WEST SUSSEX COUNTY COUNCIL CONSULTATION

TO:	Arun District Council FAO: Amber Willard
FROM:	WSCC - Highways Authority
DATE:	4 February 2020
LOCATION:	Bishop Tufnell C Of E Junior School, Pennyfields, Felpham, PO22 6BN
SUBJECT:	FP/251/19/PL Altering of existing west access to site to allow for vehicular access for emergency & maintenance purposes only. Drop kerb formed to allow for vehicular crossover, area to include a new area of secure bin storage for the school. fence off waiting area separating it from public access & existing vehicular entrance areas.
DATE OF SITE VISIT:	N/A
RECOMMENDATION:	Advice
S106 CONTRIBUTION TOTAL:	N/A

Drawing: EXISTING & PROPOSED PLANS

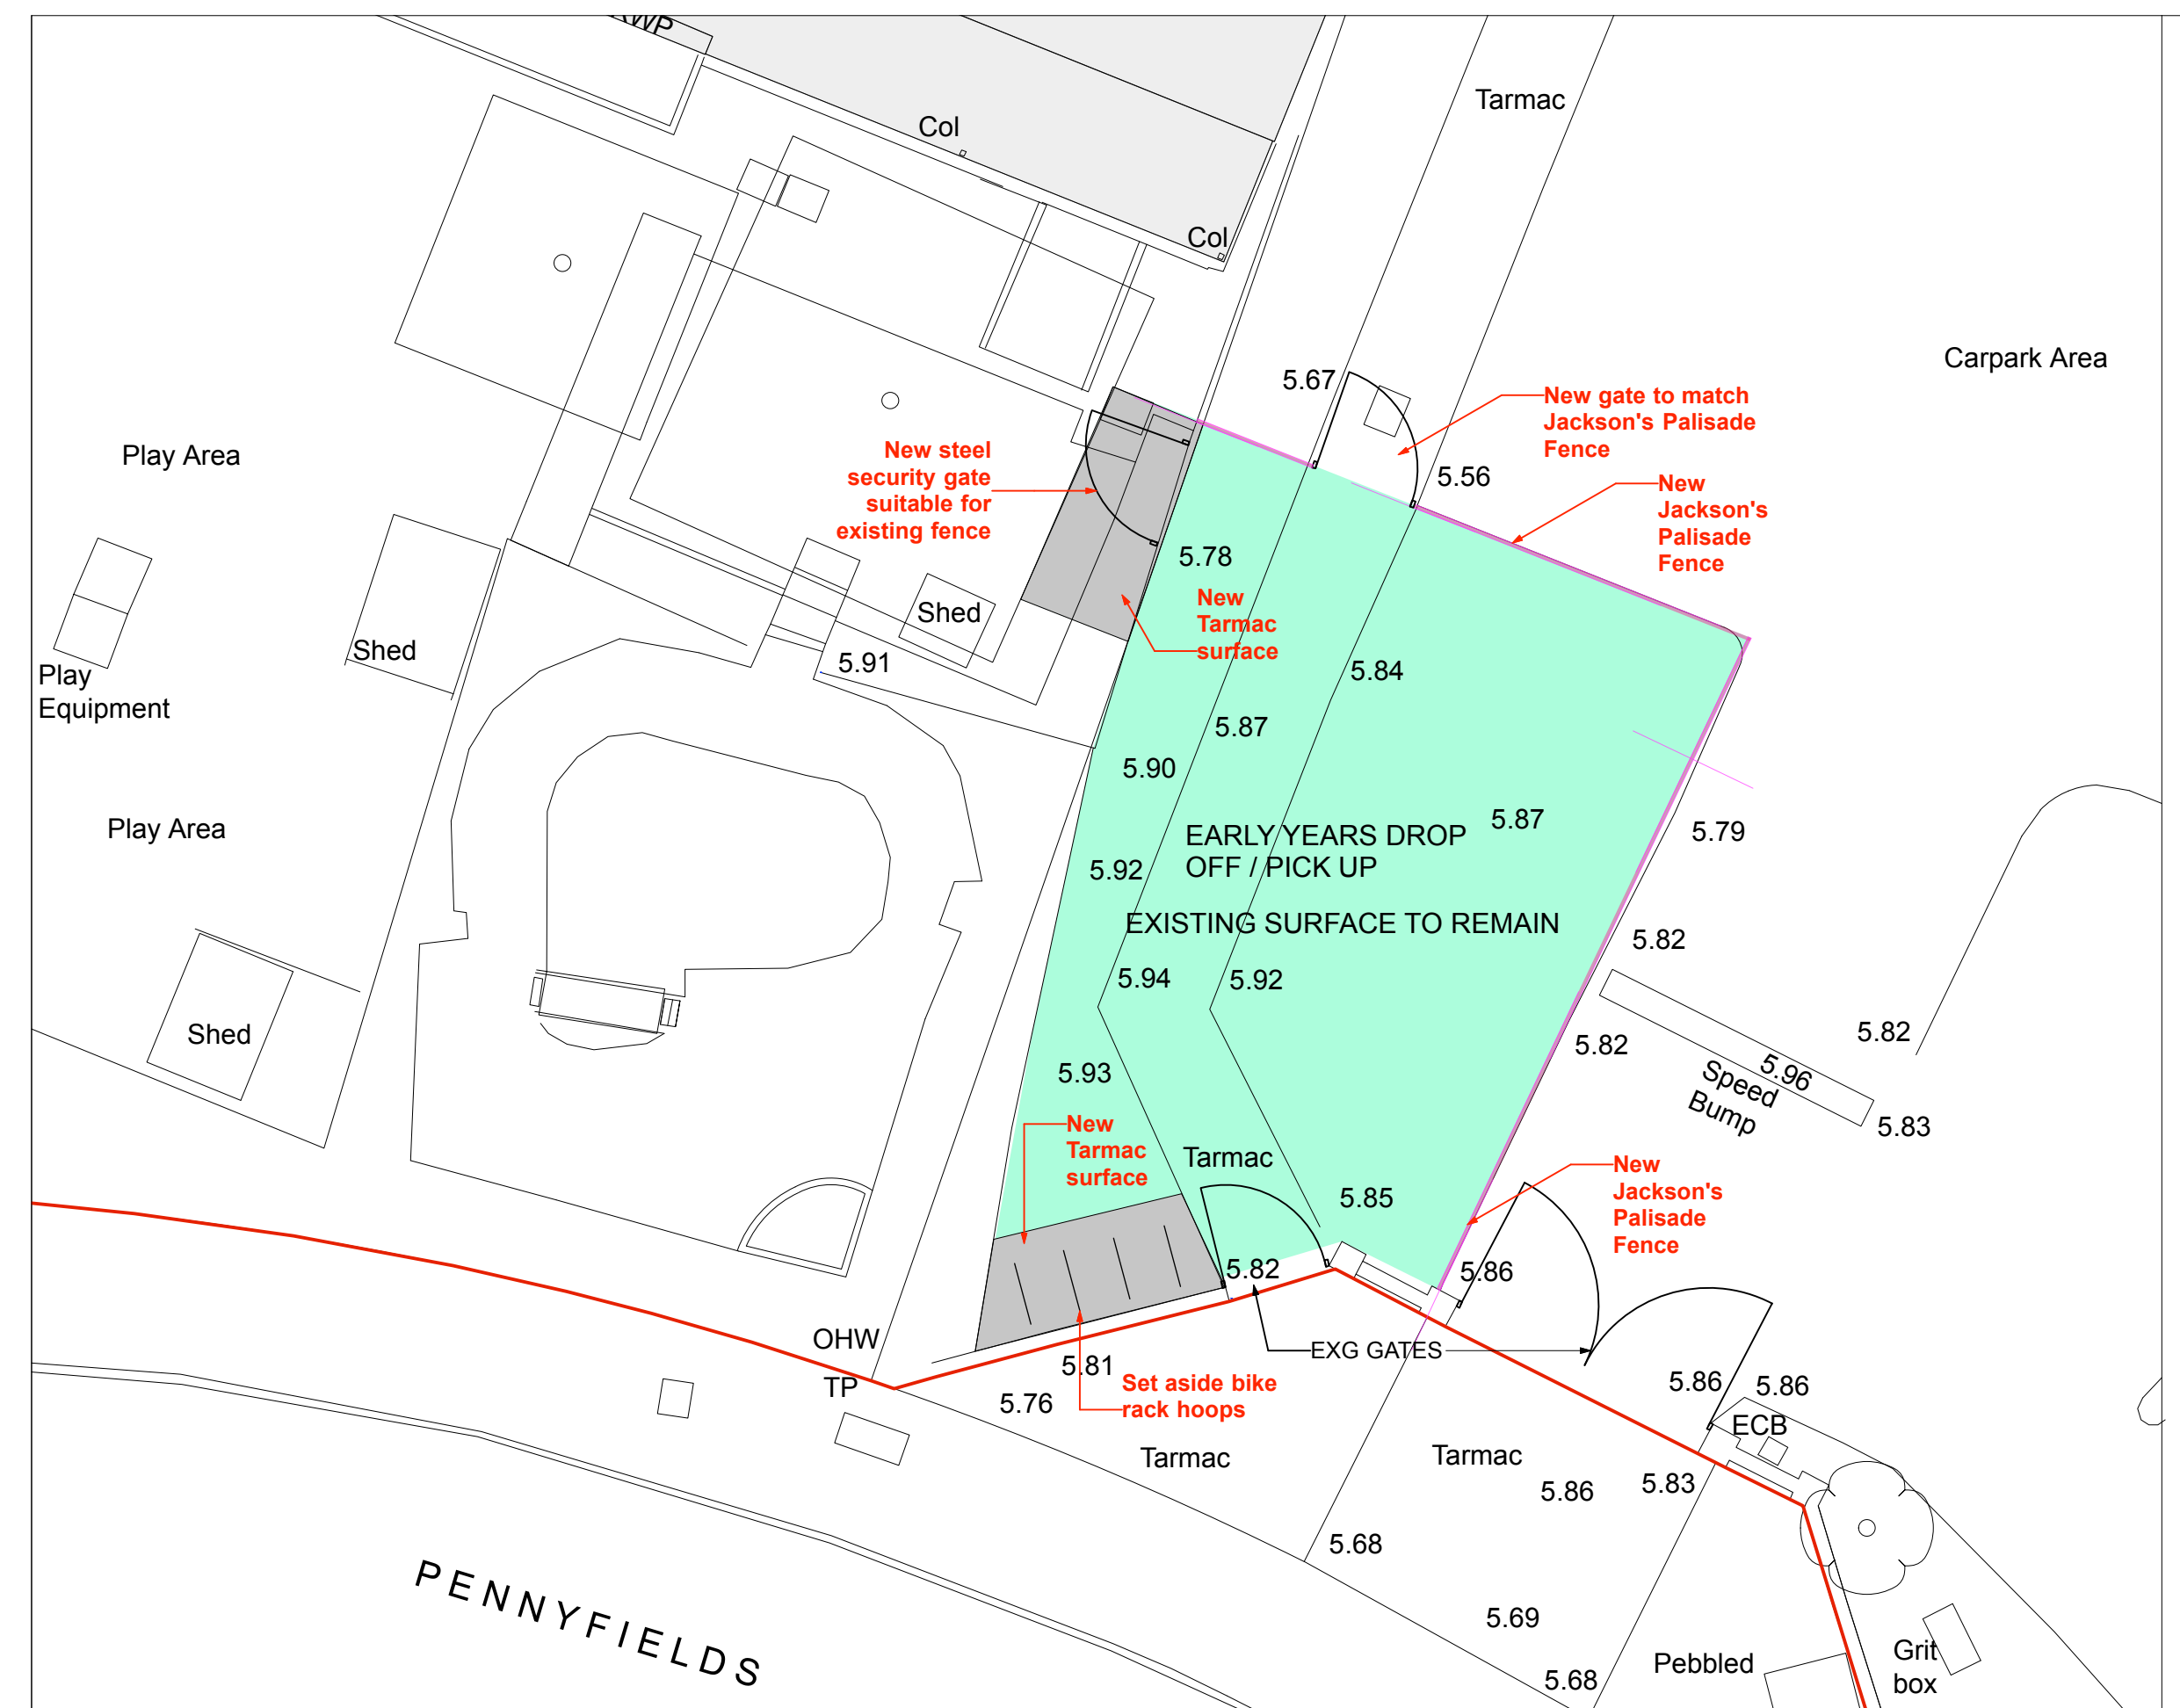
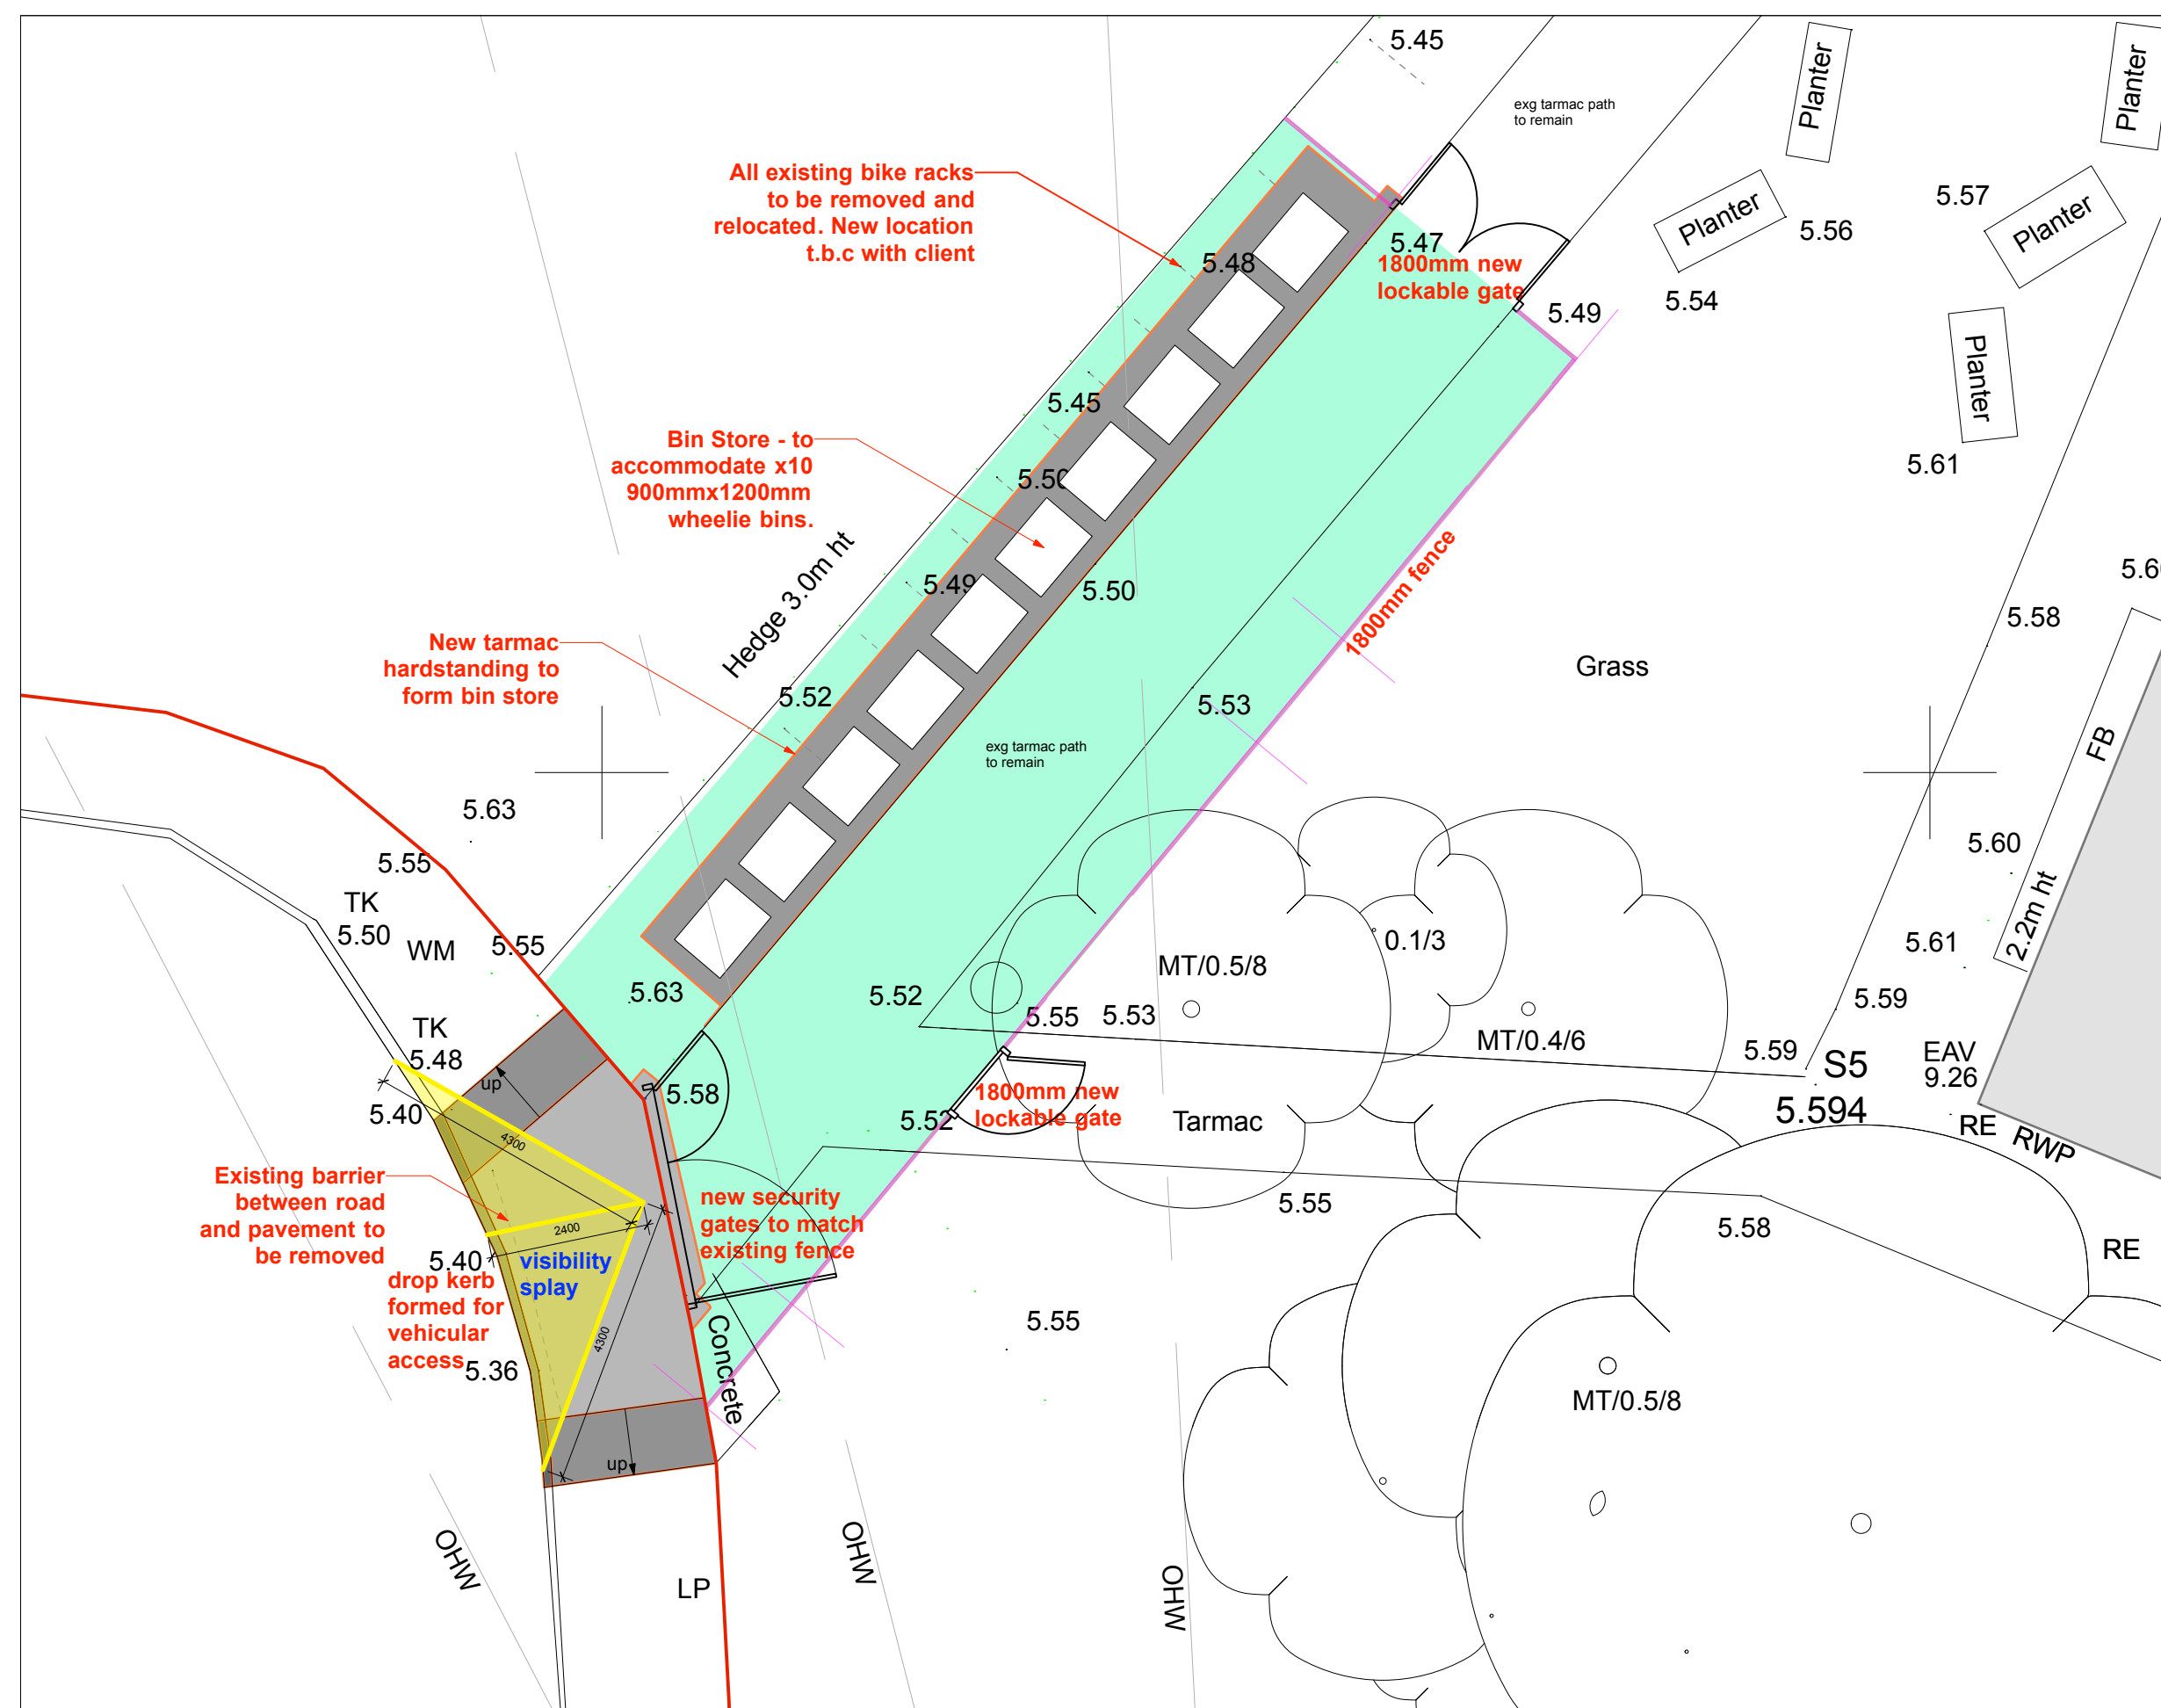
The existing early years drop off/pick up area to the east of the site is to be fenced off. From inspection of local mapping, the proposed segregation would result in the loss of four existing car parking spaces. The plans suggest that these parking spaces will not be replaced. As such, parking would have to be accommodated elsewhere on site, or on-street.

The existing pupil access point to the west of the site is to be altered to form a vehicular access for emergency and maintenance purposes only. The proposed works will require a dropped kerb, which is subject to a licence obtained through the local area office. The vehicle crossover (VCO)

would be constructed to a specification agreed with the local area engineer. The works will also require the removal of the pedestrian guard railing in this location.

There are no apparent vehicular visibility issues at the proposed access. However, the LHA requests that boundary hedging for two metres either side of this access point (and two metres within the site) is replaced with railings or similar to ensure maximum pedestrian visibility is provided in this location.

No part of the development shall be first occupied until pedestrian visibility splays of 2 metres by 2 metres have been provided either side of the proposed site vehicular access onto Pennyfields in accordance with plans and details to be submitted to and approved in writing by the Local Planning Authority. These visibility splays shall thereafter be kept free of all obstructions over a height of 0.6 metre above adjoining carriageway level or as otherwise agreed.
